From: Gregg, Robert <Robert.Gregg@lancashire.gov.uk>
Sent: 20 February 2019 13:49
To: Stephen Kilmartin
Cc: planning; LHS Customer Service
Subject: APP. 3/2019/0069 - 63 LITTLEMOOR ROAD, CLITHEROE

Single storey rear extension and conversion of western end of garage to create utility.

PROPOSED PLANS

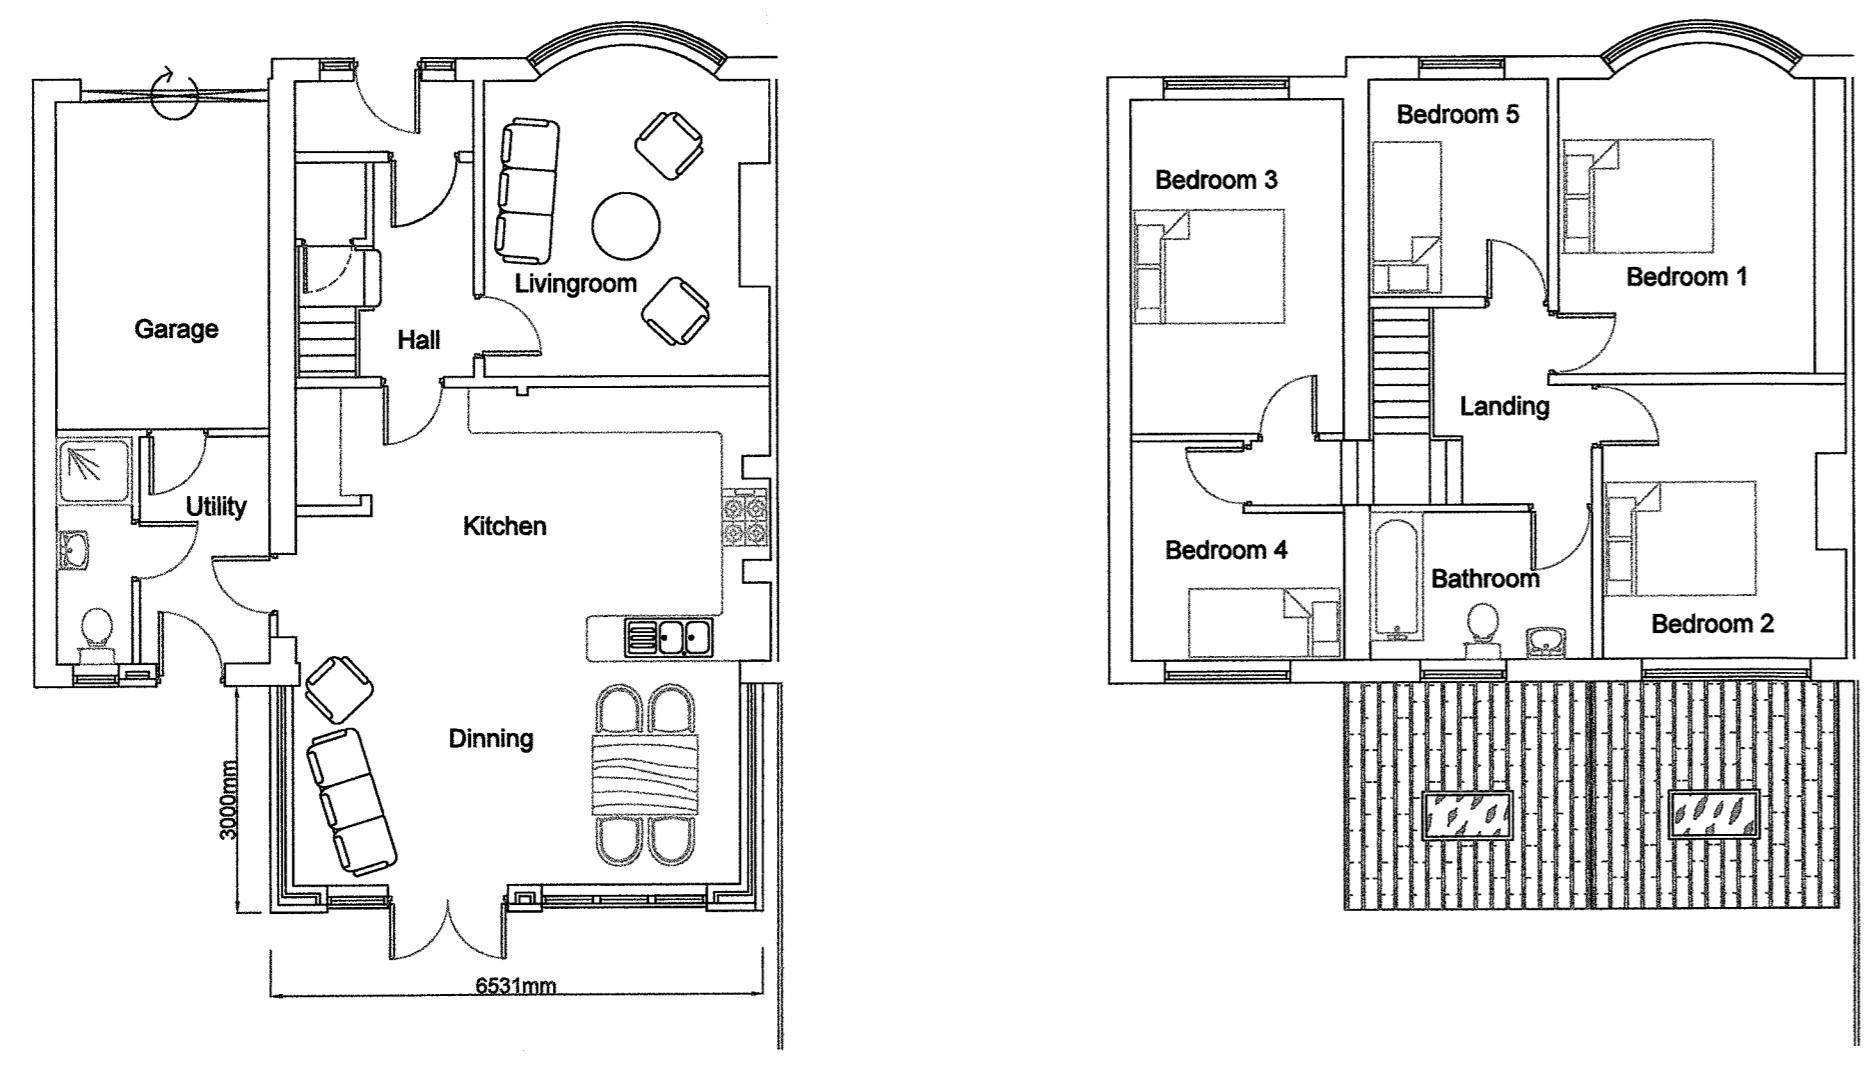
63 Littlemoor Road is a 5 bedrooomed dwelling and as such 3 parking spaces are sufficient for the proposal, whilst the property is to be retained as a 5 bedrooomed dwelling the conversion of the western end of the garage to create a utility room as proposed would prove the garage to be considered insufficient as a parking space.

The existing garage is 7.2m in length whereas the introduction of a utility room as proposed would reduce this length to 4.2m, as such this would not be considered sufficient for its intended purpose as a parking space.

I would therefore require a scaled drawing which demonstrates the proposed parking arrangements for the proposal. Three parking spaces will need to incorporated within the curtilage of the dwelling, the garden area fronting the dwelling has potential to create 3 parking spaces while also the garage equally has the potential to be extended so that a length of 6 meters can be achieved for a parking space.

I would ask that the plans be revised.
